Subject: CM/48/20/DOC- Bairds Farm Shop, Field Rear of Crookthorn Lane Climping BN17 5SN

Engineers Comments Regarding Condition 5- Surface Water Drainage

| DWG NO<br>003                                           | REVISION<br>P5 |                  |                                                        |                                                   |

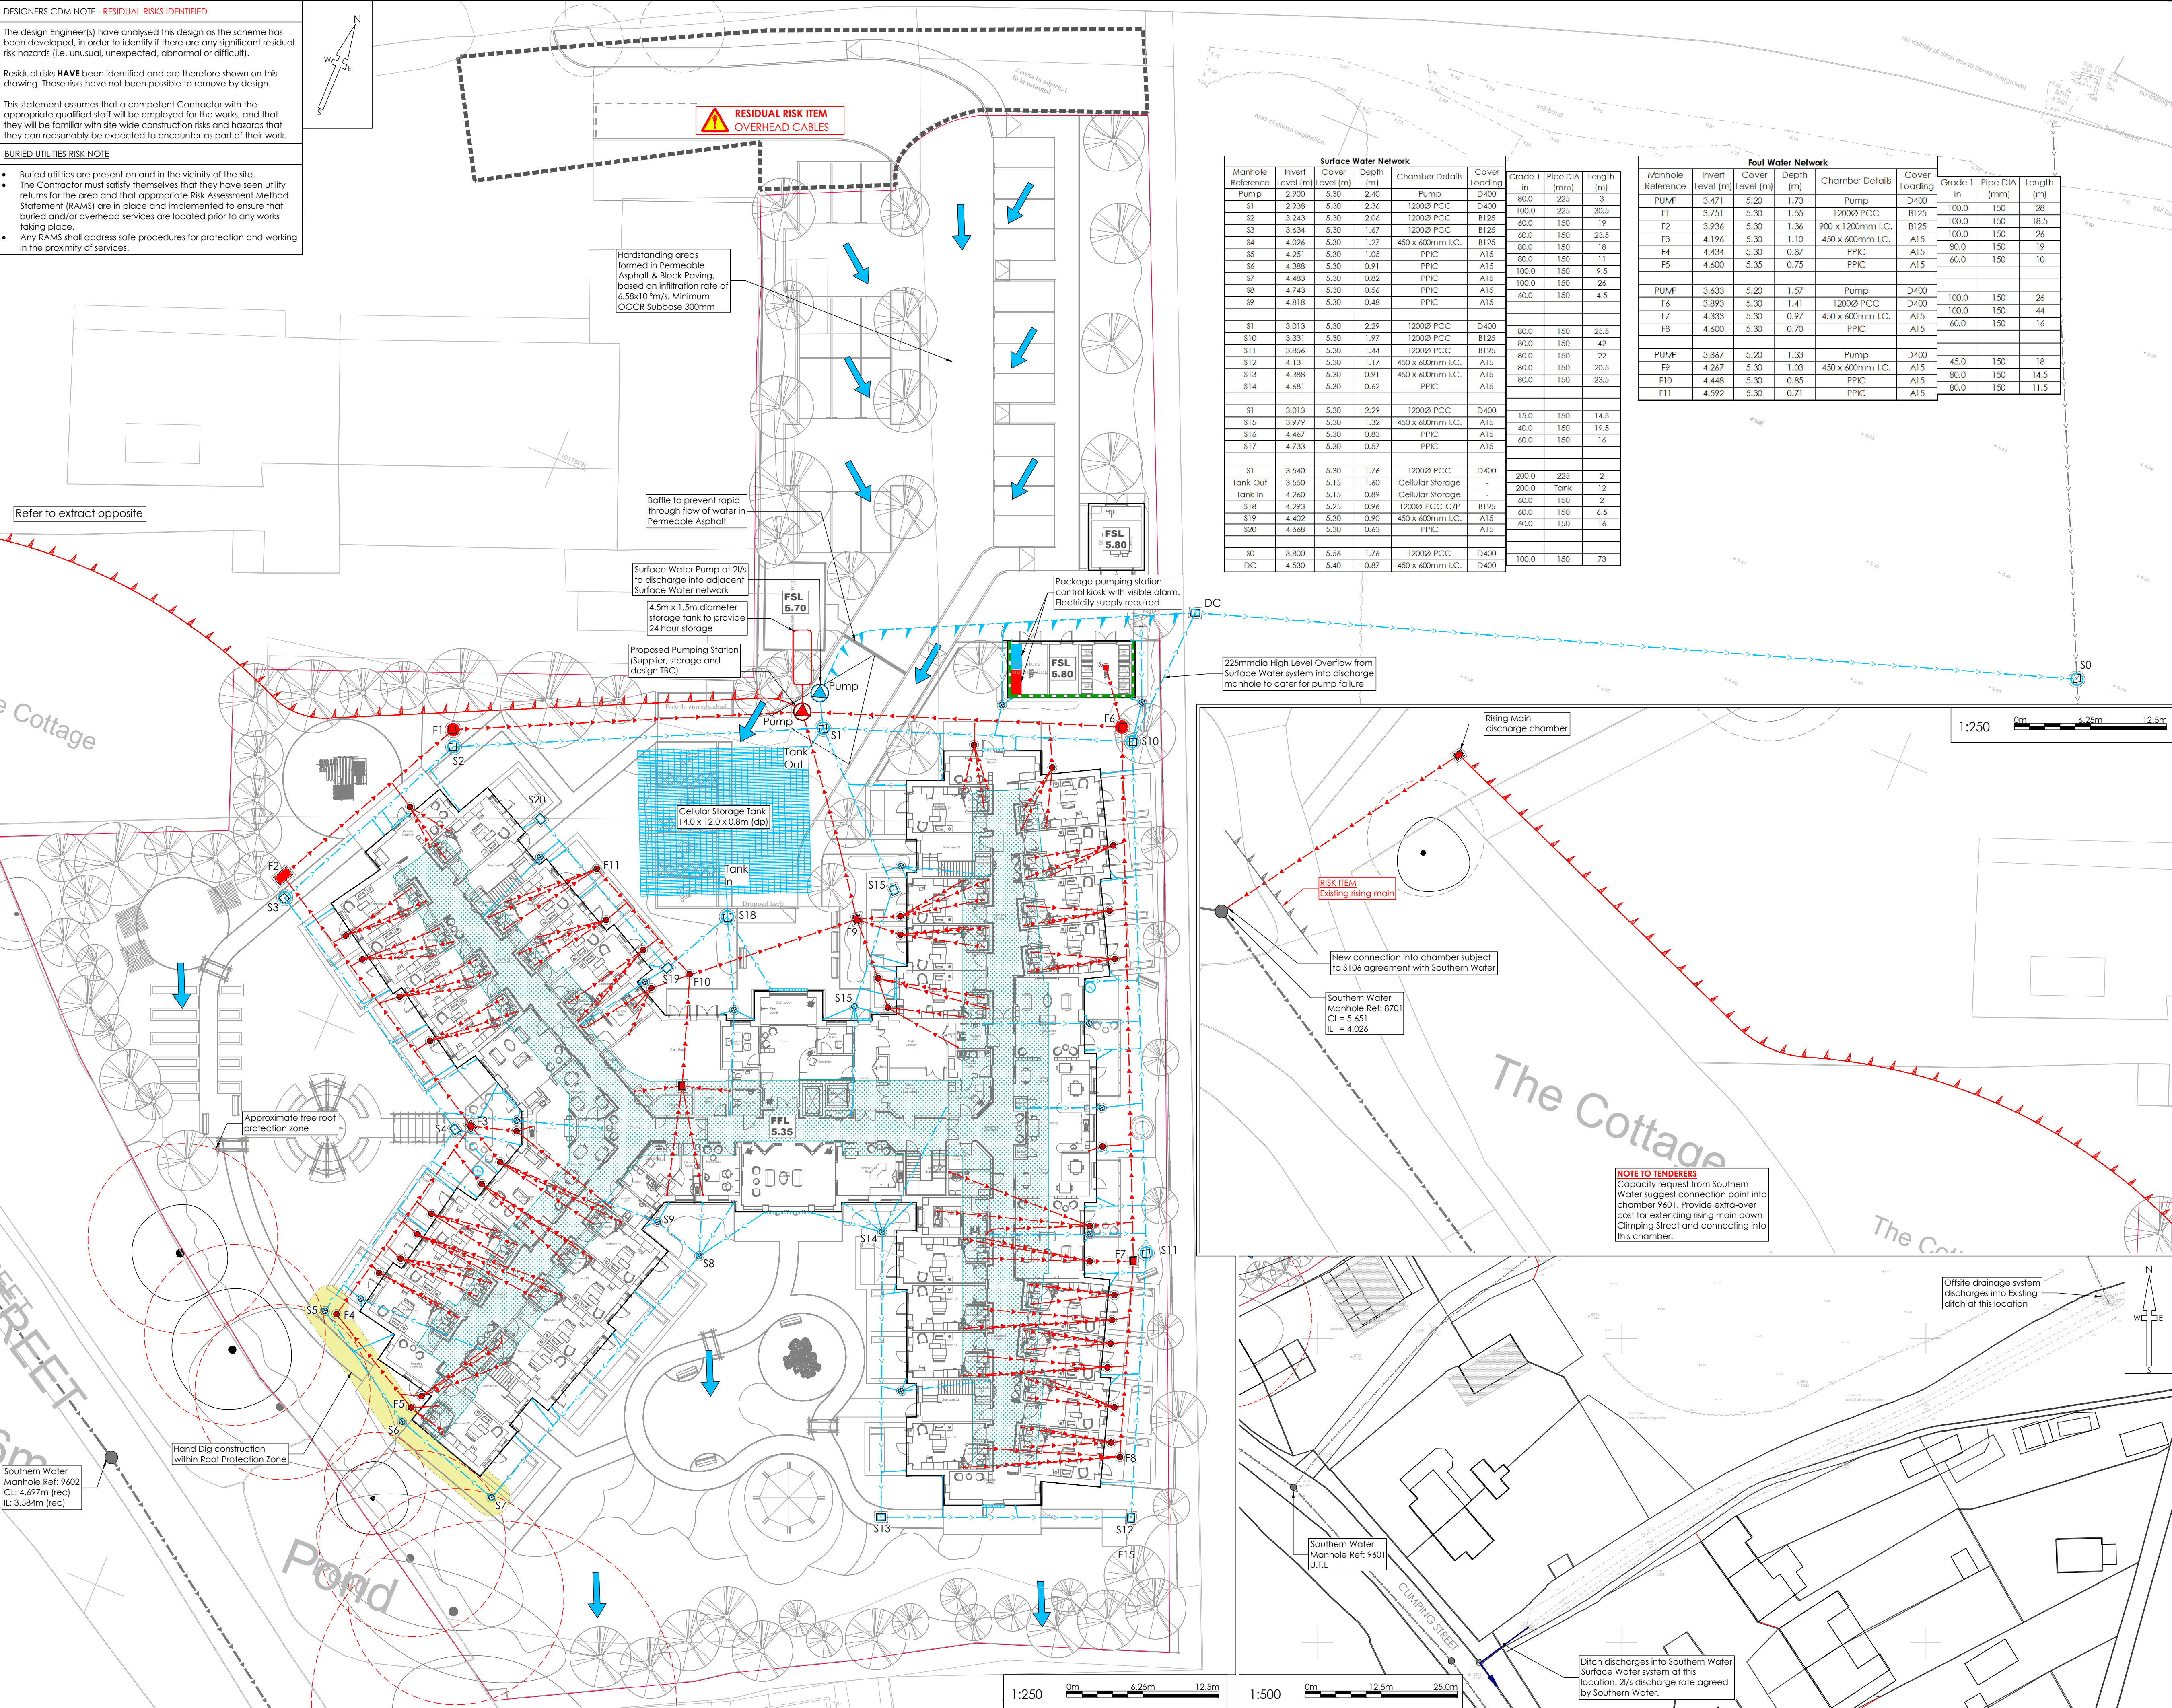
The proposals submitted include pumping of surface water. Pumping must be avoided unless it is demonstrated that all possible alternatives are not feasible. Pumping is not sustainable, pumping stations are also prone to breaking and causing flooding.

The strategy submitted does not detail the maximum area that can be drained to infiltration. Please can this information be supplied.

1. The culverted ordinary watercourse that runs north south along the developments eastern boundary. We believe this may be what the applicant refers to as a private surface water sewer, however our records indicate the culvert is further west. A connection may be more suitable at a different location- i.e. further south.
2. The pond within the application boundary- does this have an outlet?
3. The ordinary watercourse to the west of Climping Street

It is also evident from the proposed overflow connection to the culverted ordinary watercourse that a gravity connection is feasible to some extent and that it may be that storage is not being kept sufficiently shallow.
